Application for a Non-Material Amendment Following a Grant of Planning Permission

Replacement dwelling and relocation of vehicle access.

3/2023/0223

HLS-RALA-ZZ-XX-DR-A-(PL)-0002_P02 - Proposed Plans
HLS-RALA-ZZ-XX-DR-A-(PL)-0003_P03 - Proposed Elevations

1 Front Elevation (North West) 1:100

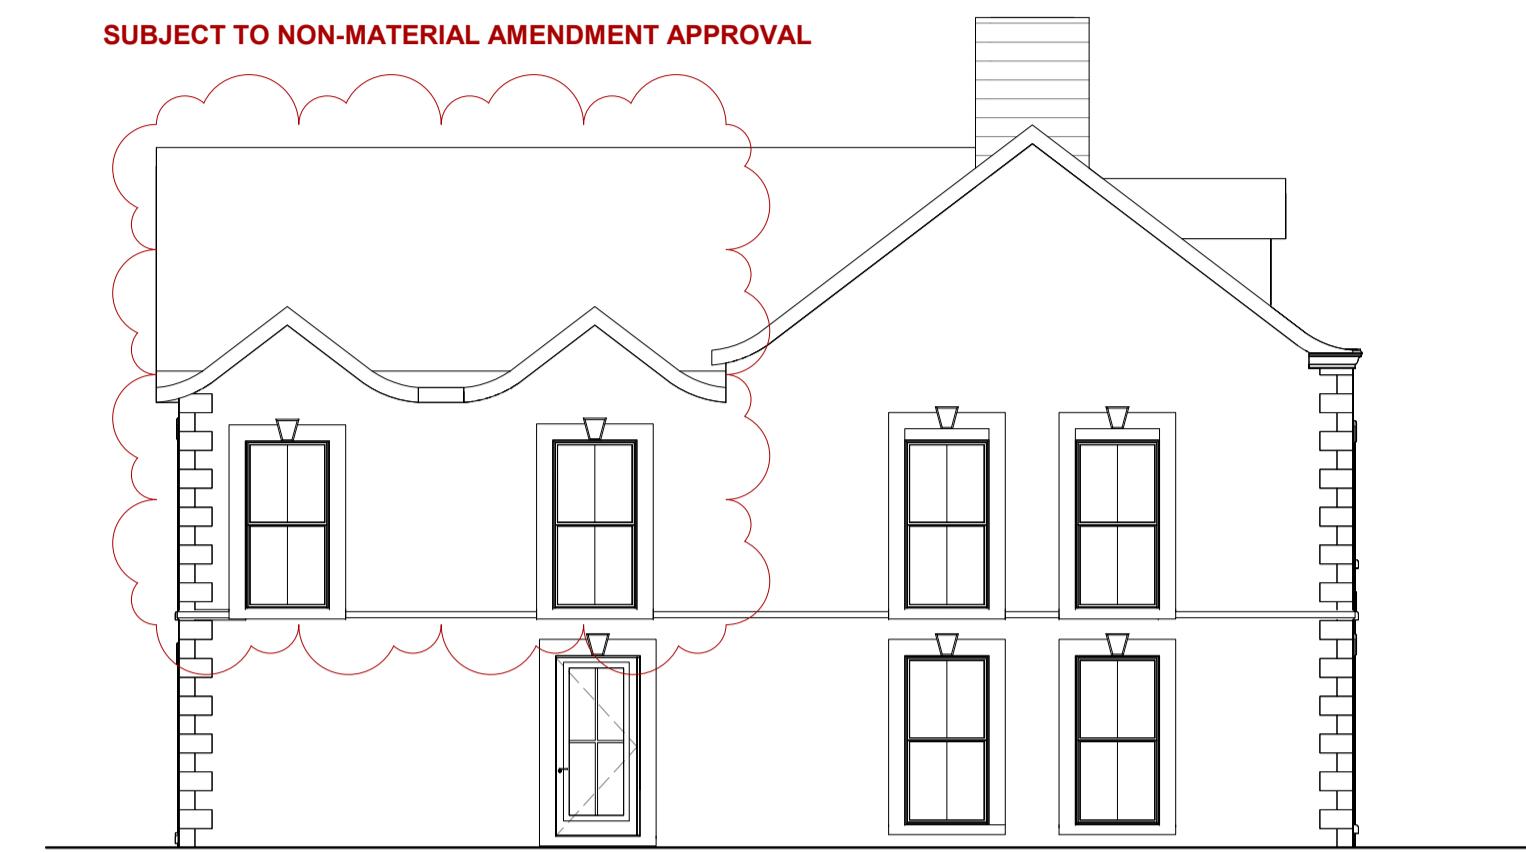
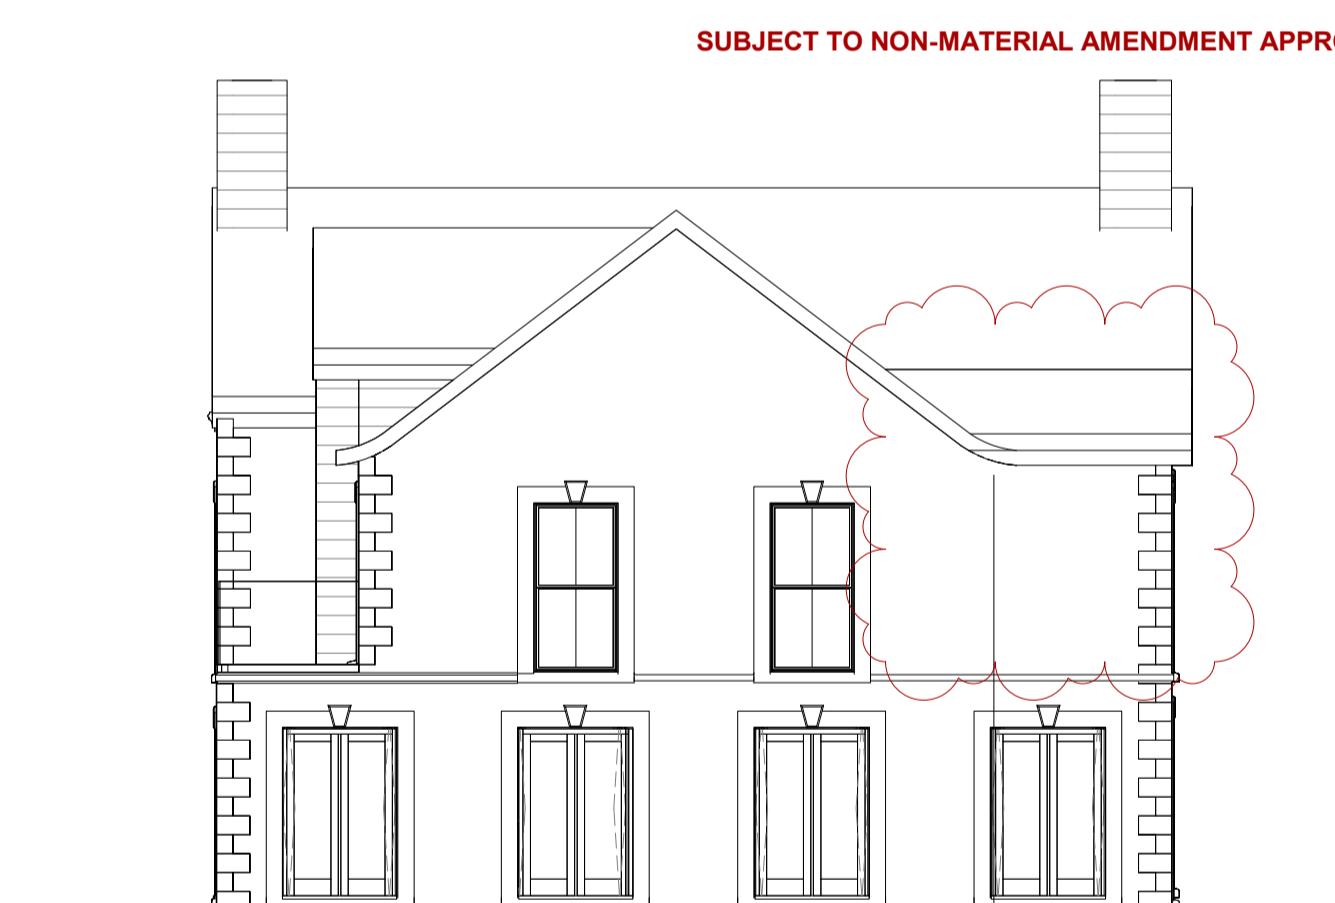
Arched entrance door, arched dormers and full height windows to front elevation

Additional windows to circulation core, removal of windows to utility, full height windows and first floor alterations to Moor Lane Elevation

Removal of canopy and reduction in glazing to rear elevation, replaced by french doors, full height windows to first floor and first floor alterations to Rear Elevation

Removal of canopy and reduction in glazing to side elevation, replaced by french doors, full height windows to first floor and master bedroom full height window changed to arched

Pre cast stone detailing added to all windows and doors on all elevations

Curved eaves roof detail added to all gable eaves
